Redevelopment and Extension of Bungalow to provide first floor accommodation

Reference number: 2018/0075 Date of decision (DD/MM/YYYY): 25.05.2018 (date must be pre-application submission)

6. Condition(s) - Removal

004revD Proposed Elevations.pdf

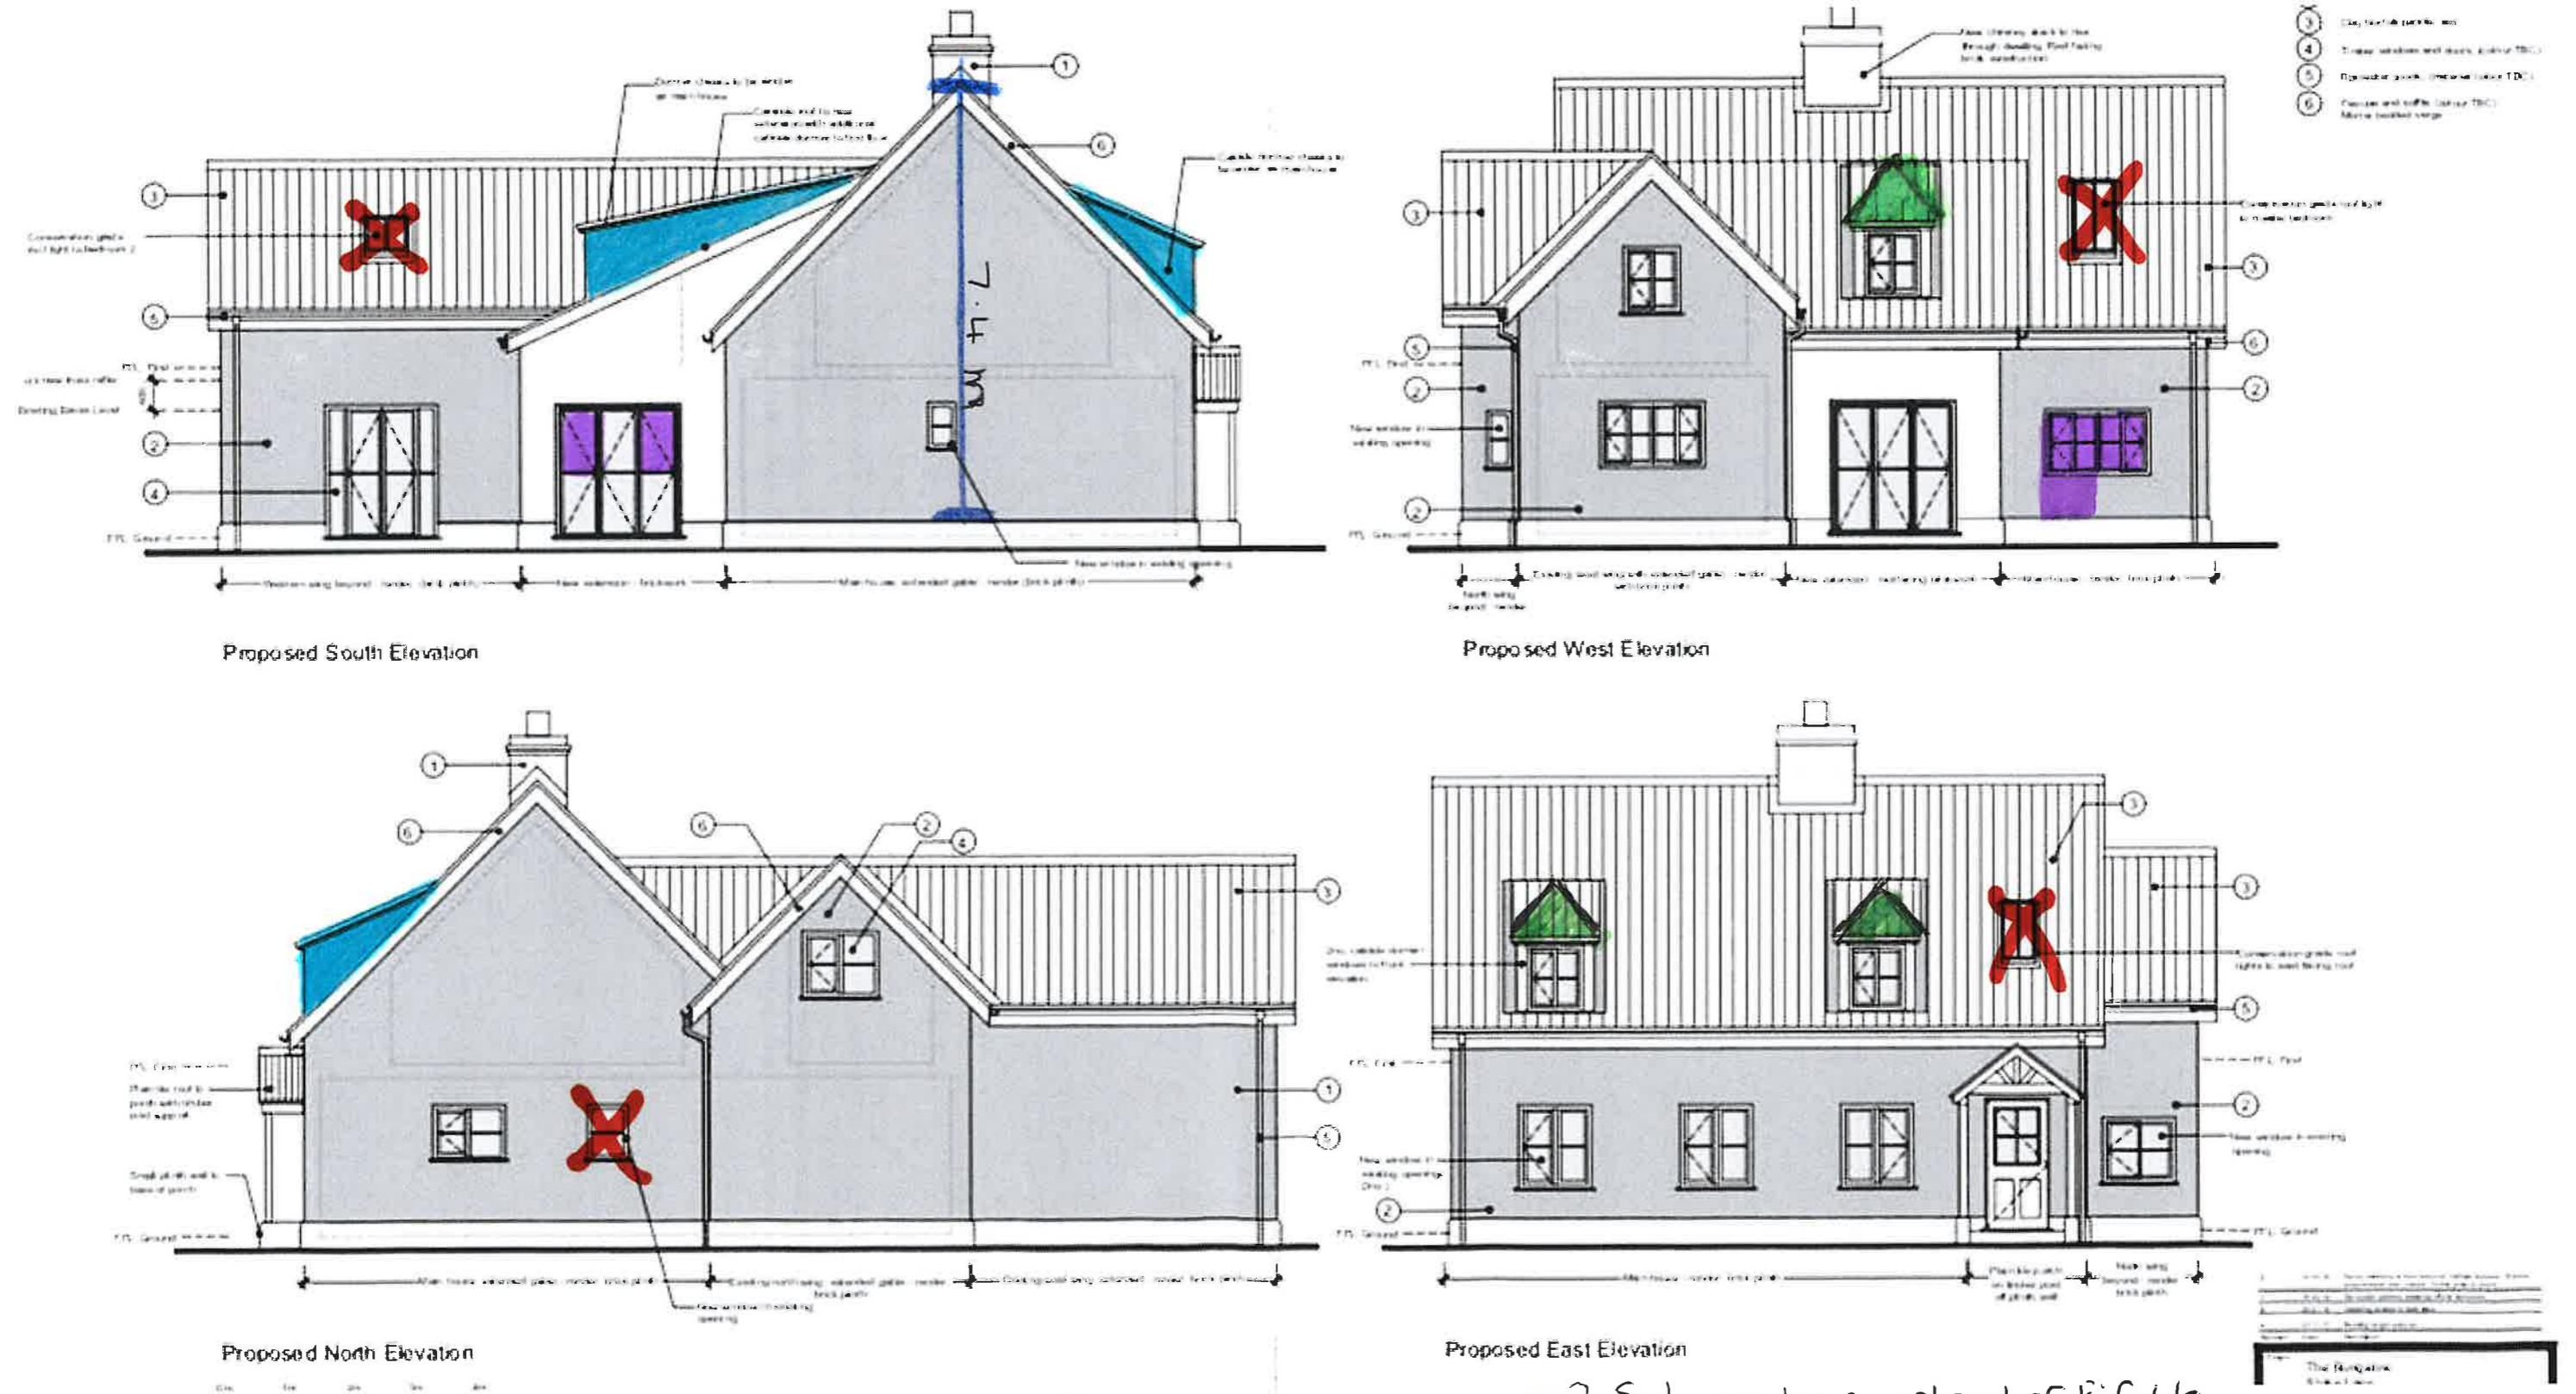
cat slides removed Bi-fold Door - north Elevation
Rendered Cat slides west Elevation - window right of door - to single door & single window

Dormer window first floor.
wooden featherboard on sides of Dormer's.

North Elevation - 2 x windows (instead of Bi-fold door)

West Elevation - stable wooden door & single window

NOTE: - THE VELUX windows have not been put in - but can stay in Permissions for later date.
